Application Reference: 2025/0622

Site Address: 37 East End Crescent, Royston, Barnsley, S71 4AW

Introduction: Erection of a single storey rear extension

PROPOSED: GA PLANS ELEVATIONS	SCALE: 1:50 1:50
-------------------------------------	------------------------

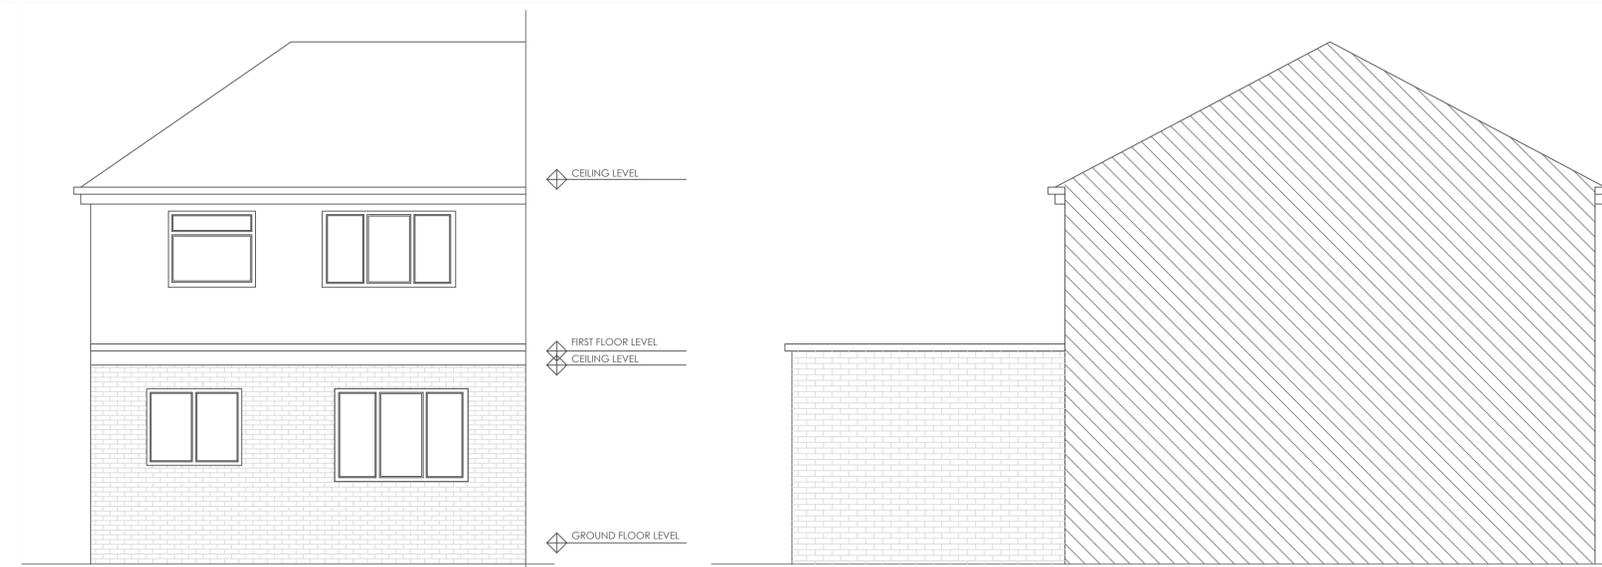
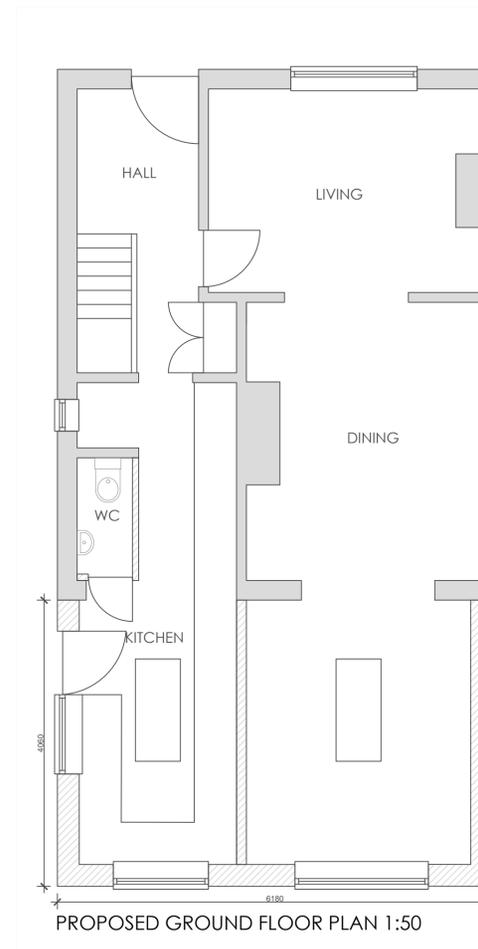
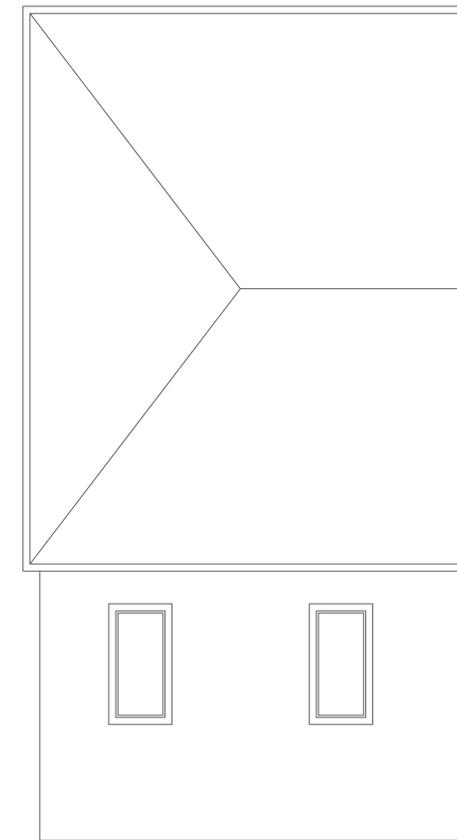
The proposed rear extension provides a rearward projection of approximately 4 metres which is considered acceptable in reference to the House Extension SPD. The roof height of approximately 3.2 metres is greater than the ideal height outlined within the House Extension SPD. Despite this, a similar proposal could be erected under a prior-notification for larger home extension application under the same circumstances and therefore it would

not be prudent to restrict this element of the proposal. Although a pitched roof would be preferred, the majority of the proposal cannot be seen from the street scene. Matching brickwork is detailed which is welcomed. The rear glazing provides similar fenestration to the existing dwelling.

The proposed extension would be erected to the north of 39 East End Crescent and so will not cause significant loss of sunlight. The proposal is screened to the south by a neighbouring detached garage preventing any possibility for overlooking and in turn reducing the impact of the proposal in terms of overshadowing and overbearing. The proposal will cause some impact to the north in terms of loss of sunlight, however, the proposal is considered acceptable given similar could be erected under prior-notification application along with no objections being received. The proposed rearward projection complies with the house extension SPD and is therefore considered acceptable.
